FIRE RISK MANAGEMENT, INC

Memo Report

Subject: Code Review; ICW Proposed Munjoy Heights Development

# UNIT B

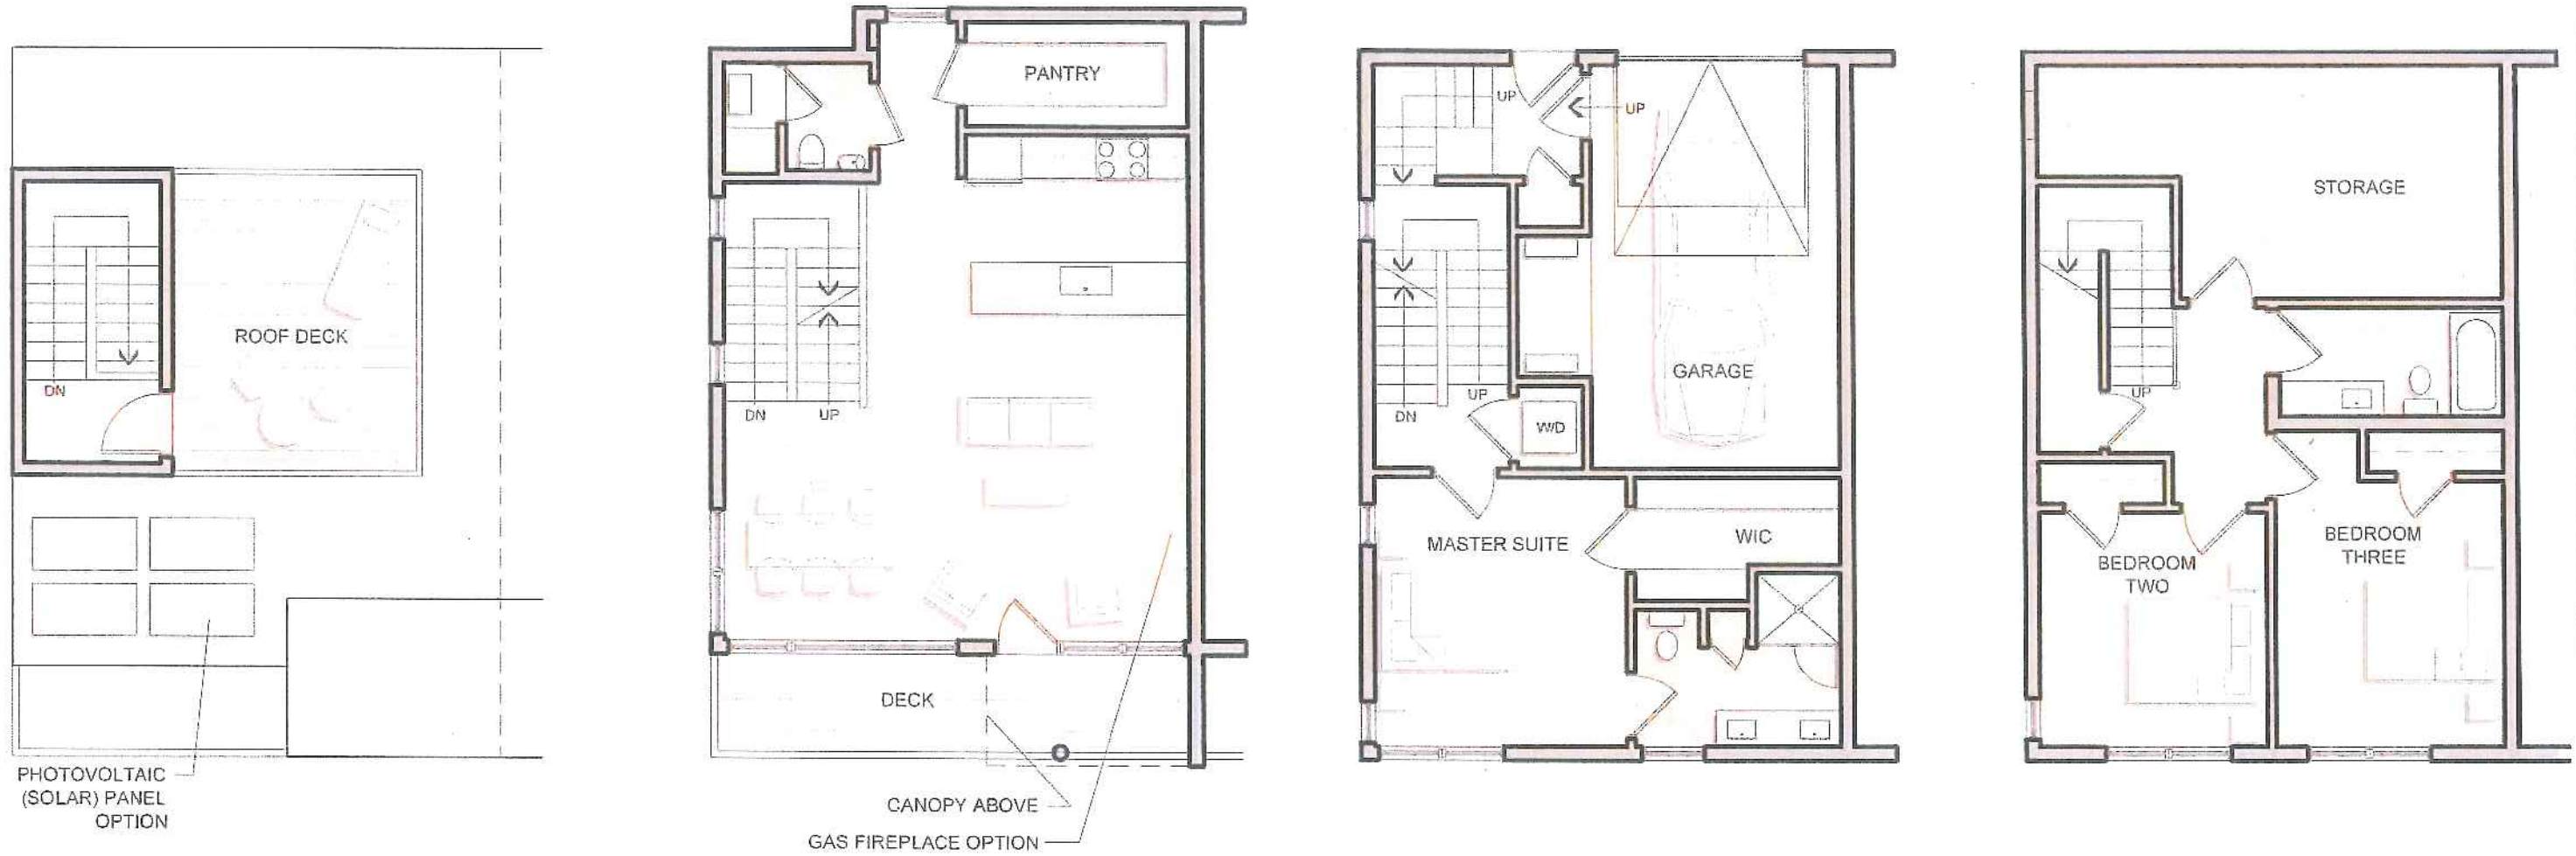
- Each living unit is being provided with an elevator. Although the code review documents provided with the architectural plans correctly indicate that no fire separation is required for the elevator shafts since they are installed completely within the individual residences and do not connect more than four stories in any of the

buildings, the floor plan drawings indicate a 1-hour fire separation for the shaft walls. This is not a code requirement and since these elevator shafts are adjacent to open stairways that connect all floors of the individual units, inclusion of these fire rated barriers would ultimately serve no purpose; either from a building protection or life safety standpoint.

DRAWING NO. **C-10**

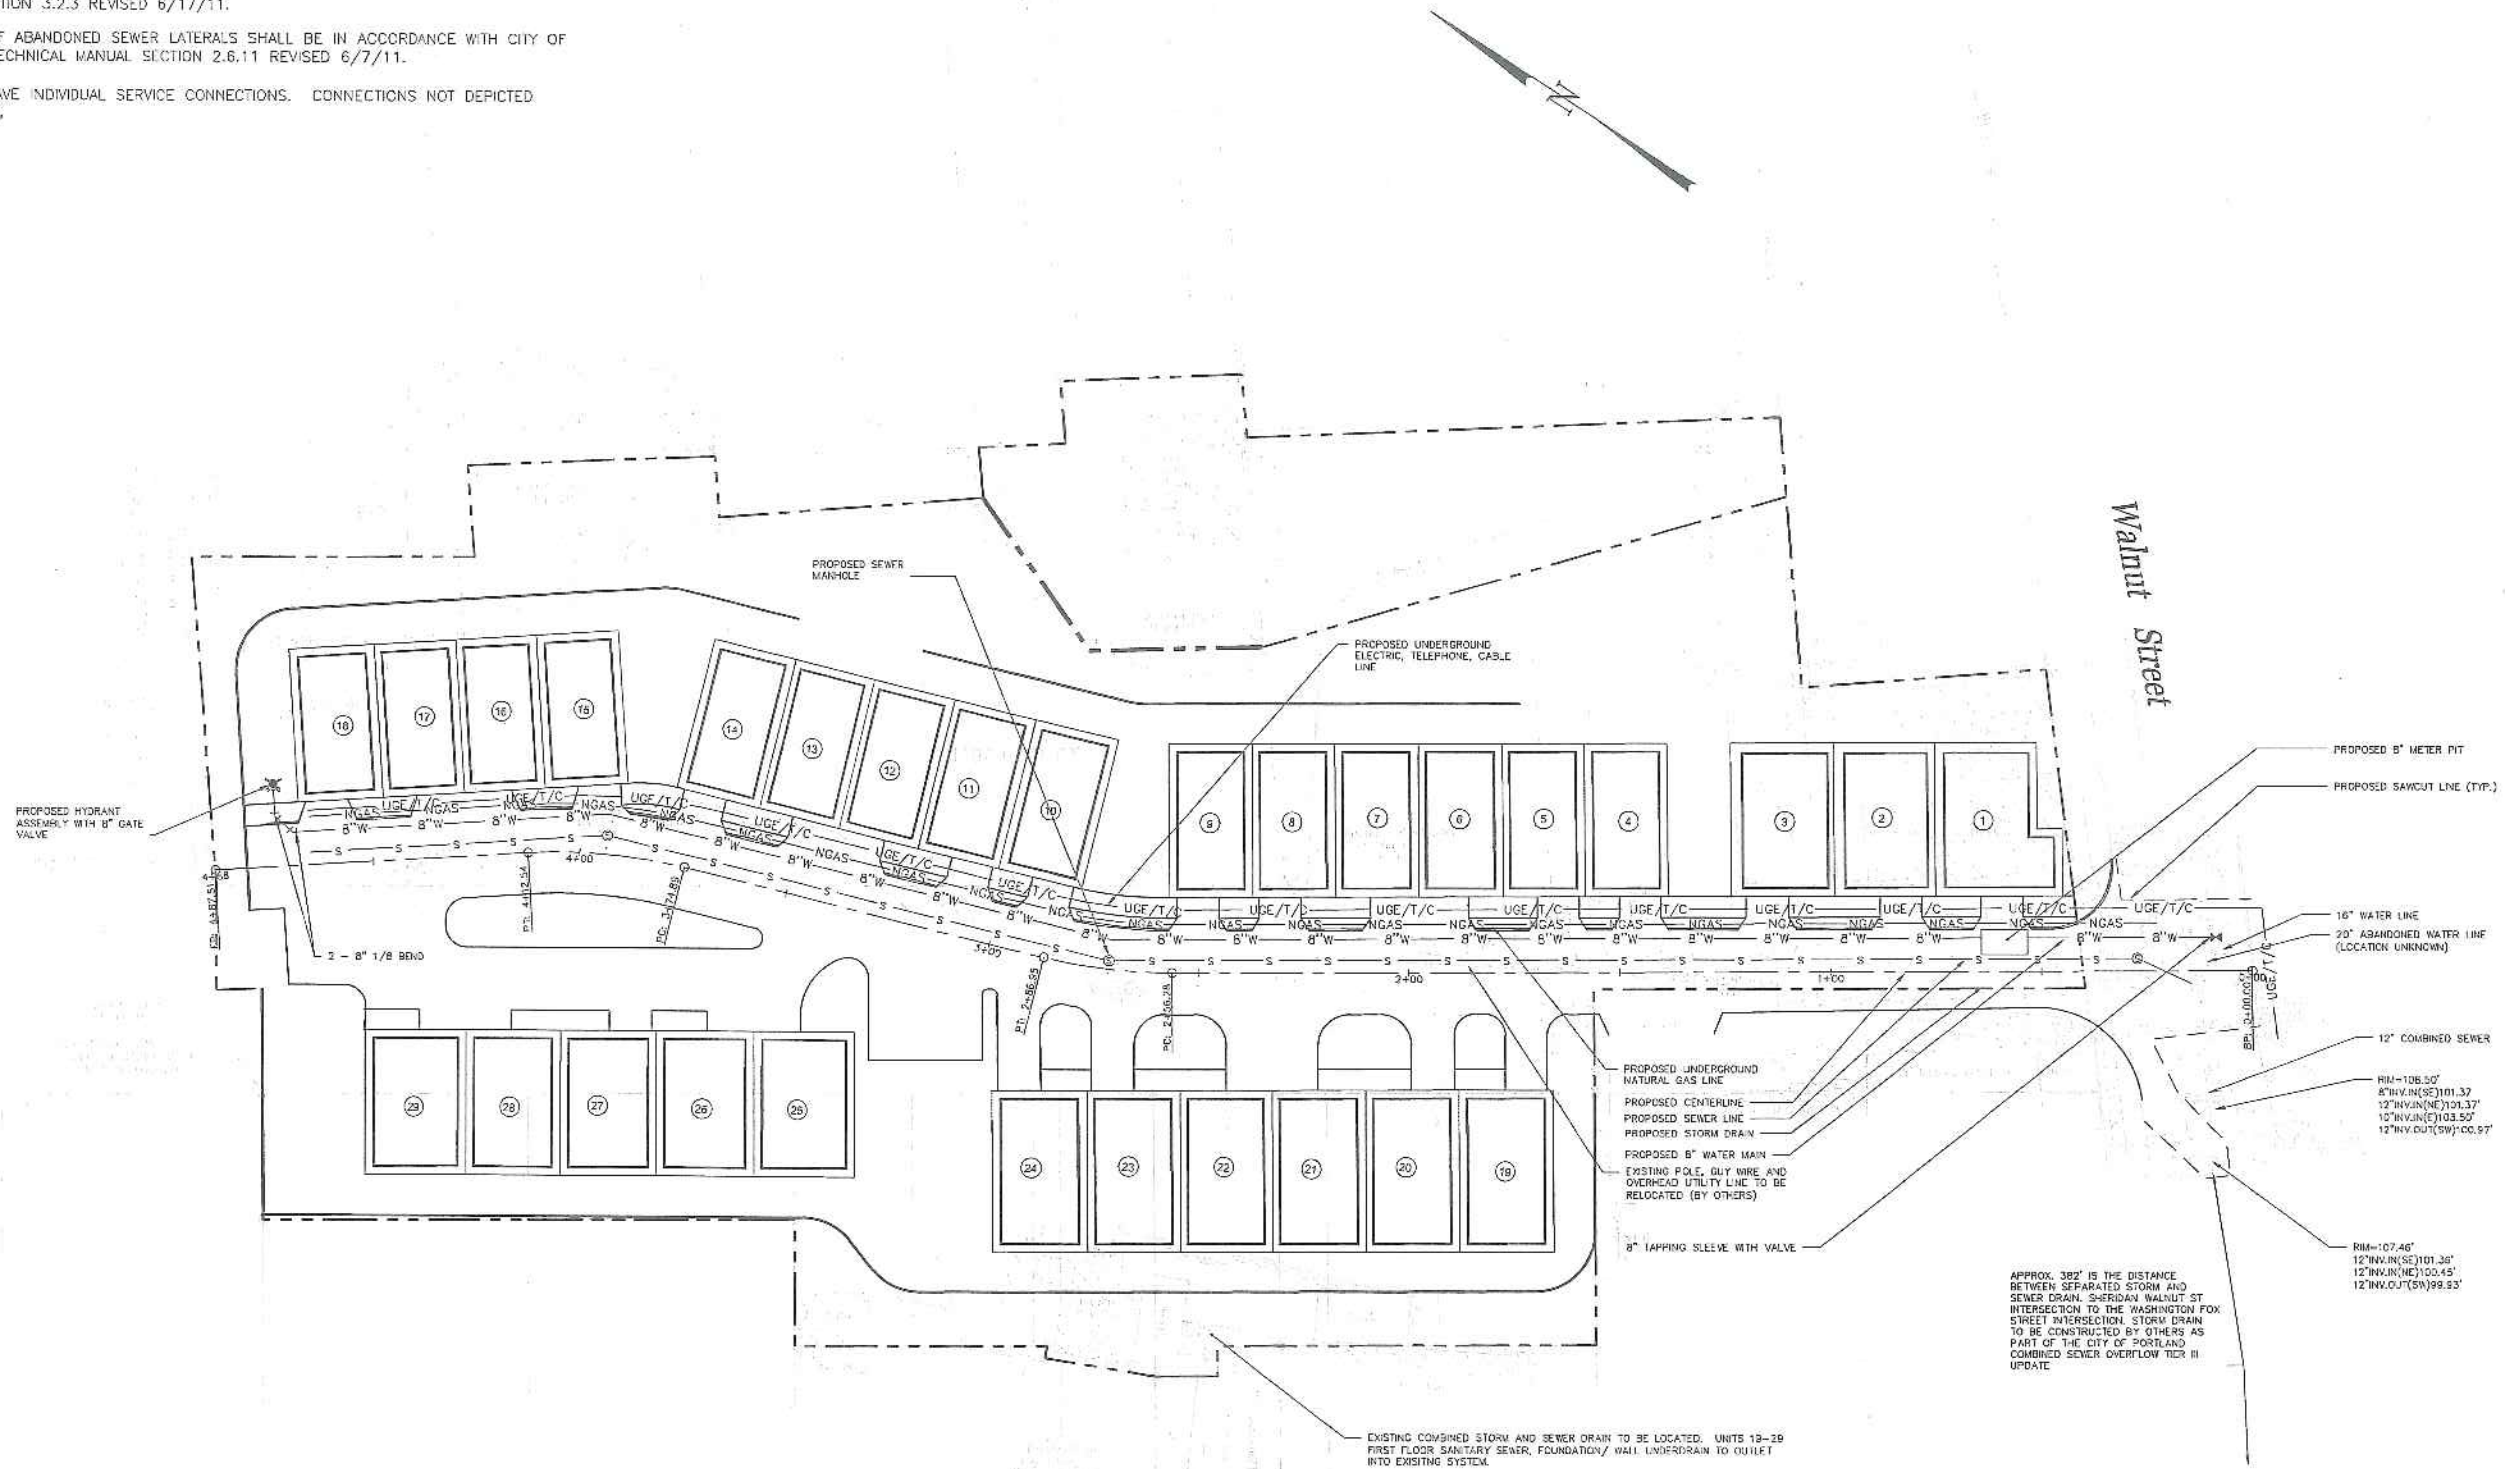
- *The City's standards require that the access road must extend to within 50 feet of an exterior door that provides access into the building. NFPA 1 has a similar requirement, but includes that when the building is provided with an automatic fire sprinkler system, this distance can be extended to 150 feet. The planned access road for this development extends all the way through the subdivision and, as such, will ensure that it will be within 50 feet of the front door of all units of all buildings; thereby still meeting the City's more stringent requirement.*

- *The access road must be at least 16 feet in width to meet City requirements. The NFPA 1 would require this access road to have at least 20 feet in clear width. The access road shown on the site plan will provide up to 20 feet of clear width along its entire length.*

- *Any dead-end access roads in excess of 150 feet must be provided with an adequate turn-around area. The total length of the access road into this development is approximately 450 feet. As such, a turn-around area is required. As depicted on the site plan, a turn-around area is provided at the end of the access road that complies with the City's requirements for this feature. Specifically, the turn-around area that has been provided is in compliance with Figure I-5, *Turnaround On Dead End Street*, that is cited by the City's Public Safety Standards*

DRAWING NO.  
**C-20**

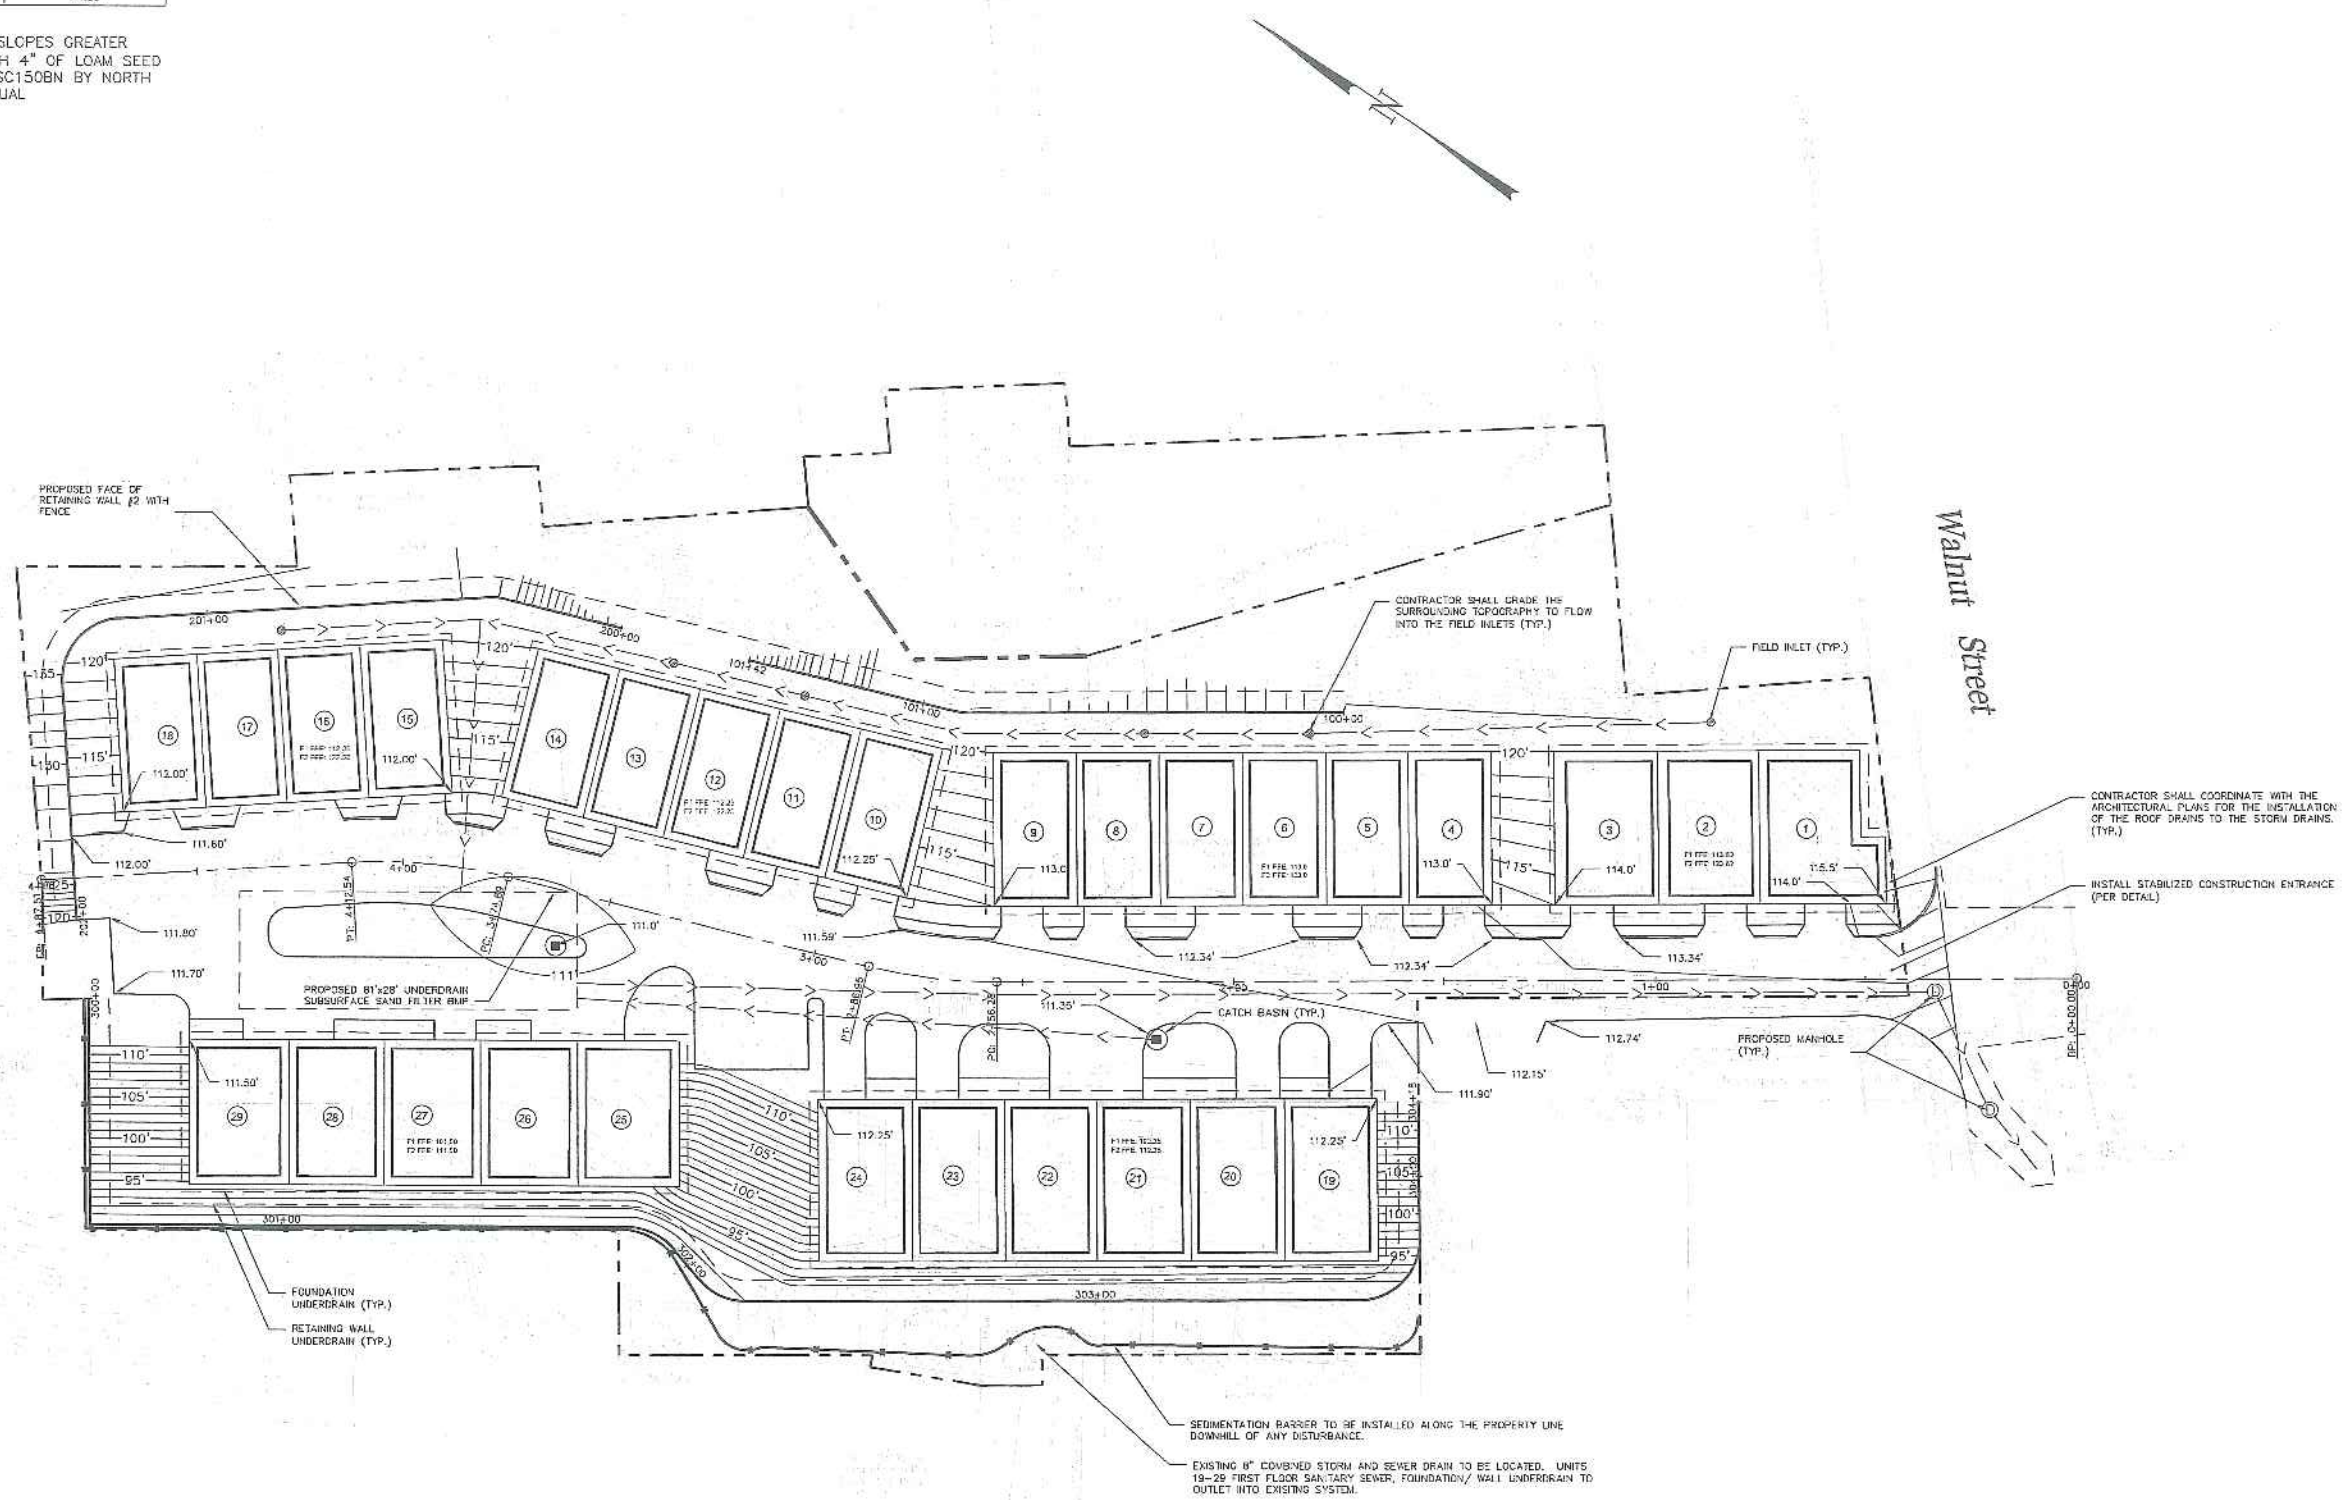
- *NFPA 1 requires that at least one (1) fire hydrant be within 250 feet of this site. The City also has a requirement that a hydrant must be within 100 feet of any Fire Department Connection (FDC). Given the water flow requirements needed to support firefighting operations, which is based on the building size and construction type, a fire hydrant must be within 250 feet of any part of the frontage on access road. A new, private fire hydrant is to be located at the end of the access road and a hydrant exists at the intersection of the access road and Walnut St. These hydrant locations ensure that all frontage on the development's access road will be within the 250-foot limit. However, the distance from the hydrants to the likely locations of some of the buildings' FDCs will be outside the 100-foot limit outlined by the City's Rules and Regulations. In recent discussions with a representative of the City's Fire Prevention Bureau, whereby the validity and benefit of this specific requirement has been questioned, it was stated that this regulation may be waived and only those requirements outlined in NFPA 1 must be adhered to for this particular project; which would require only a single additional hydrant be provided within the development.*

Based on a review of both the buildings’ design plans and the development’s site plan, along with comparing these data to the requirements needed to support fire department operations, the design plans for this townhouse complex appear to be generally compliant. The only item that will require further discussion with the City is verification that the need to have a fire hydrant within 100 feet of all buildings’ FDC will not be required for this development.

With the exception of the distance between the closest fire hydrant and the buildings’ FDCs, the site design plan for this building should meet all requirements for site access and water supply as outlined in both NFPA 1 and the City’s Rules and Regulations. In addition to obtaining verification from the City that it will not be required that all FDCs be within 100 feet of a hydrant, it is also recommended that unless the property owner has requested additional fire separation between the individual units to better assure property protection, that consideration be given to removing the 2-hour fire-rated barriers that currently subdivide each building. The limited benefit of adding these additional barriers may not warranted, given the likely costs associated with their construction.
